CITY OF ALBUQUERQUE

November 28, 2017

RE: **6508 Camino Del Oeste NW
Lot 15 Block 2 SAD 228
Volcano Cliffs Subdivision
Grading and Drainage Plan
Engineers Stamp Date 11/26/17 (D10D003G15)**

ENGINEER'S SEAL  11/28/17 11/26/17 DAVID SOULE P.E. #14522	6508 CAMINO DEL OESTE	DRAWN BY WCMJ
	GRADING AND DRAINAGE PLAN	DATE 11-23-17
 1606 CENTRAL AVENUE SE SUITE 201 ALBUQUERQUE, NM 87106 (505) 872-5999		21811-LAYOUT-10-16-17
		SHEET #
		JOB # 21808

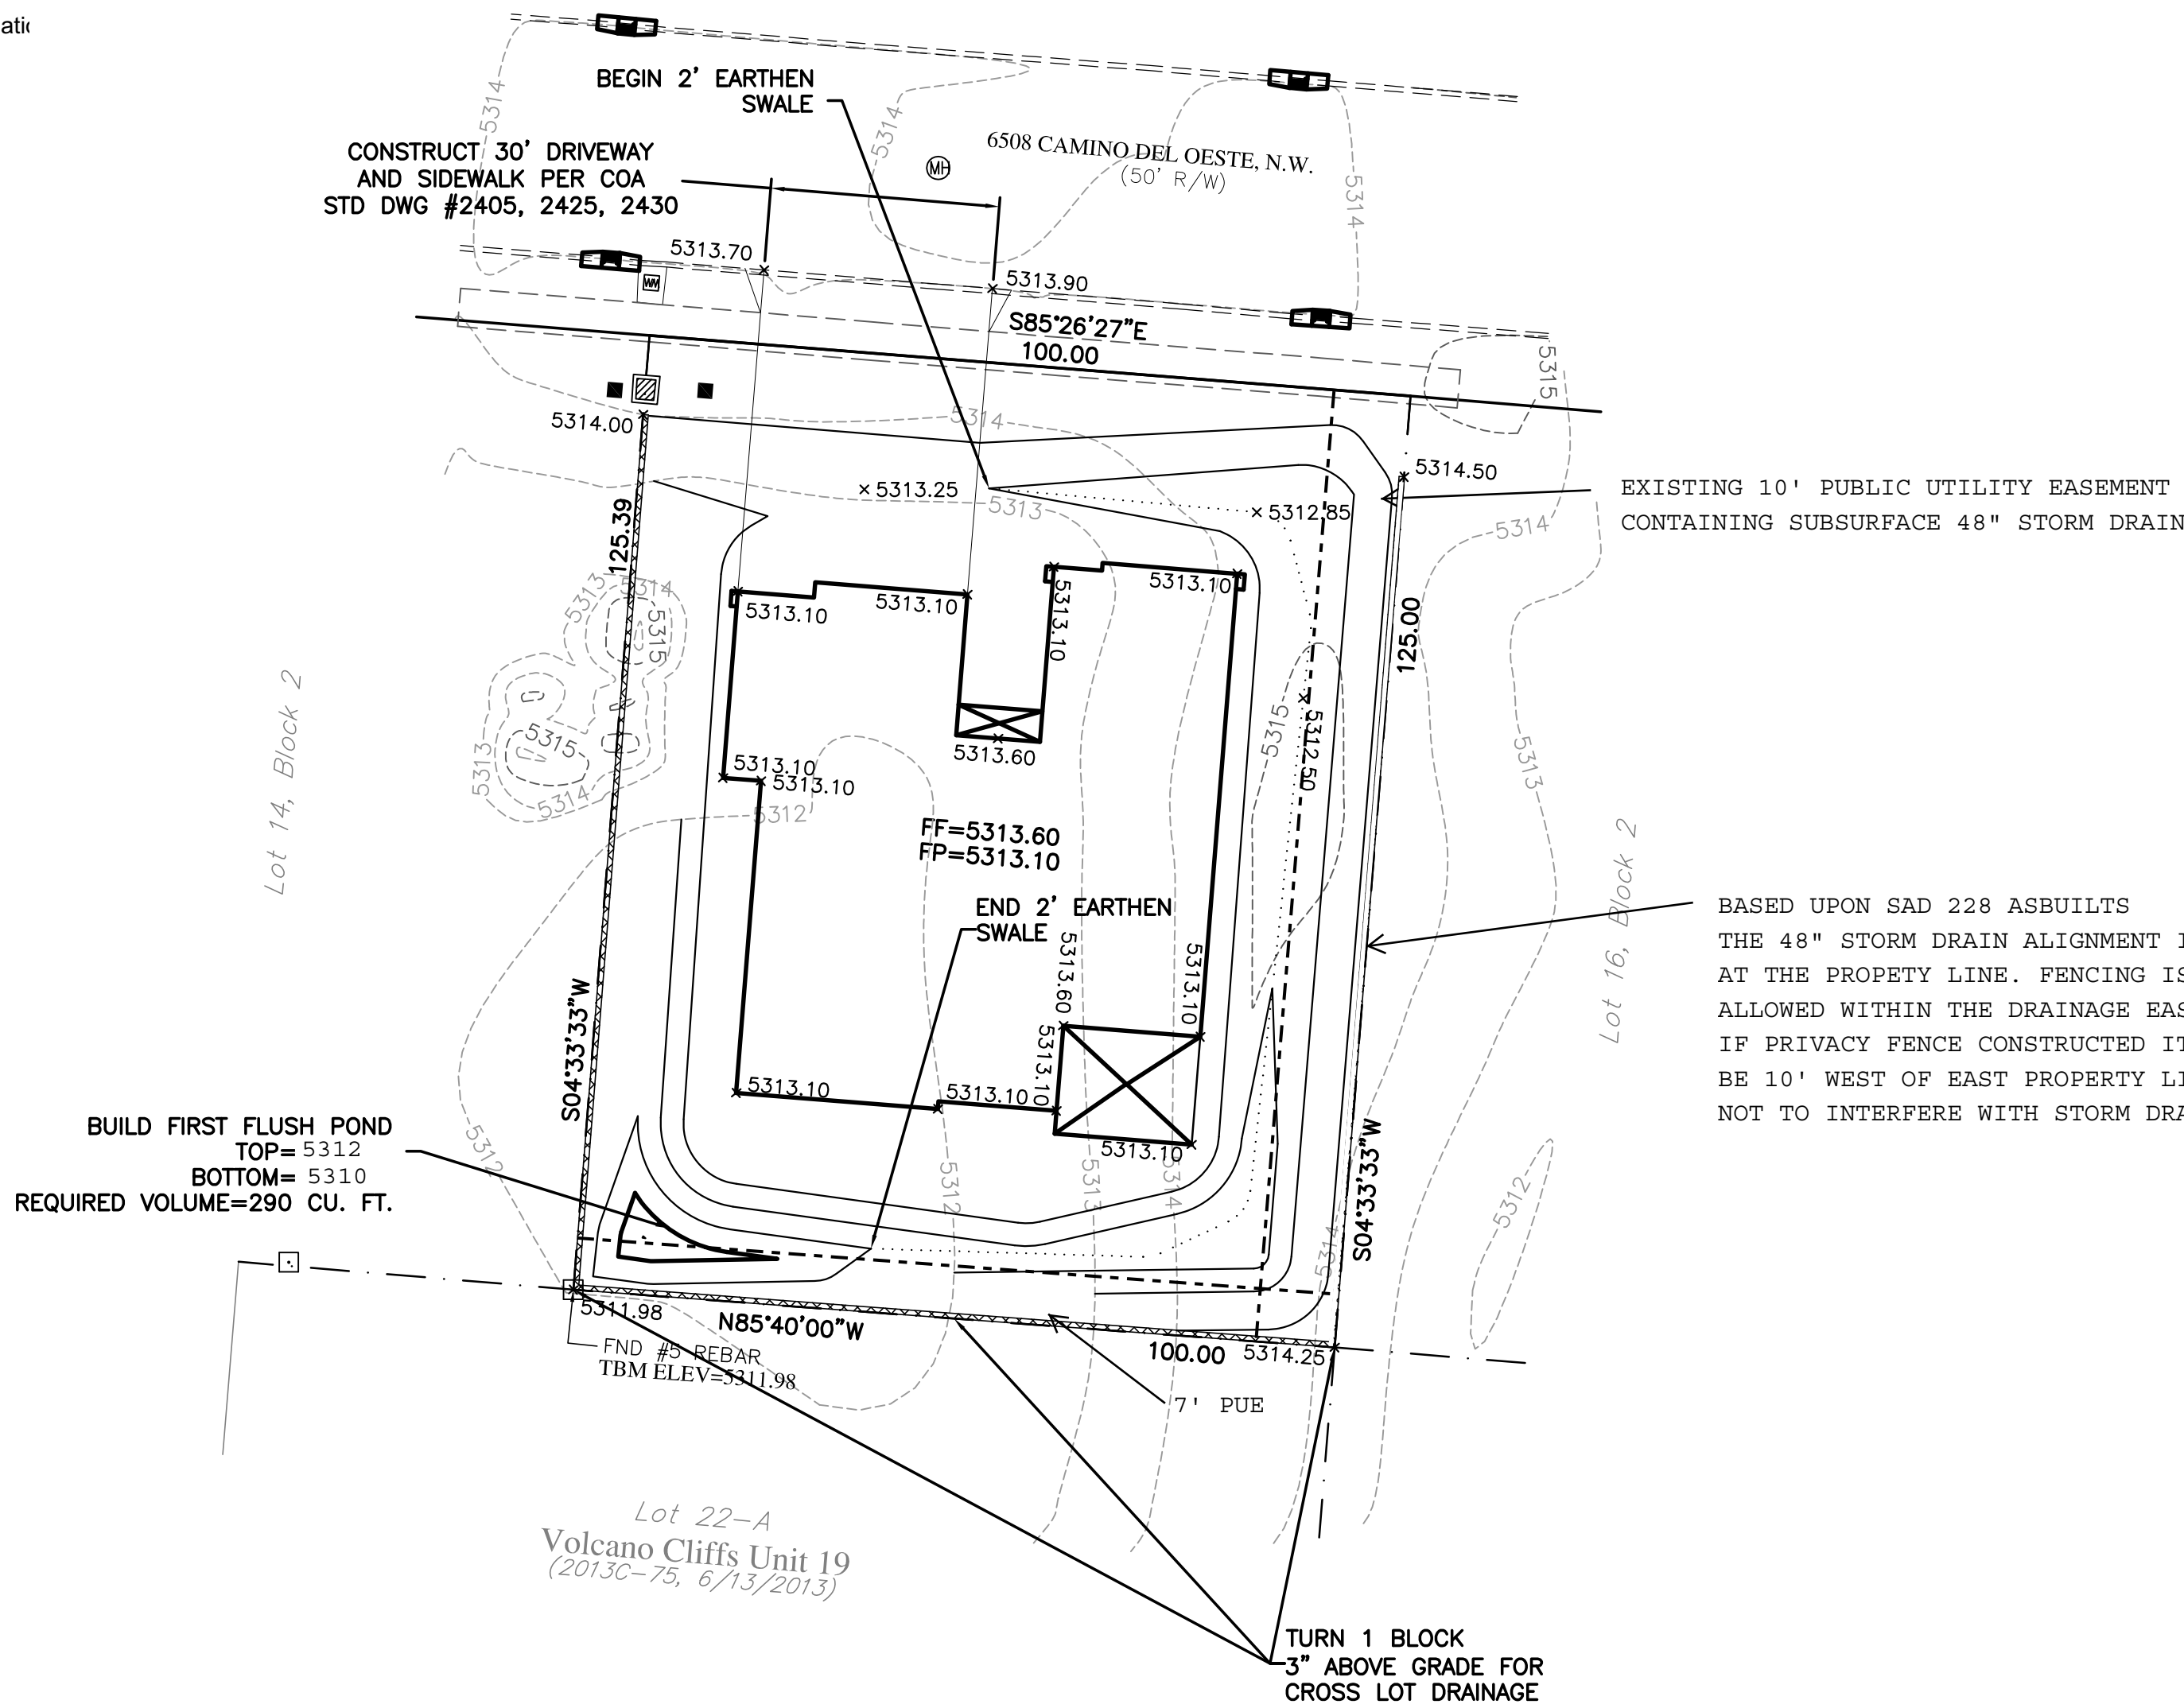
- Show the 10' PUE and the location of the 48" drainage pipe in the PUE on the east side of the property.
- Avoid placing the garden wall in this location, on top of 48" drainage pipe.
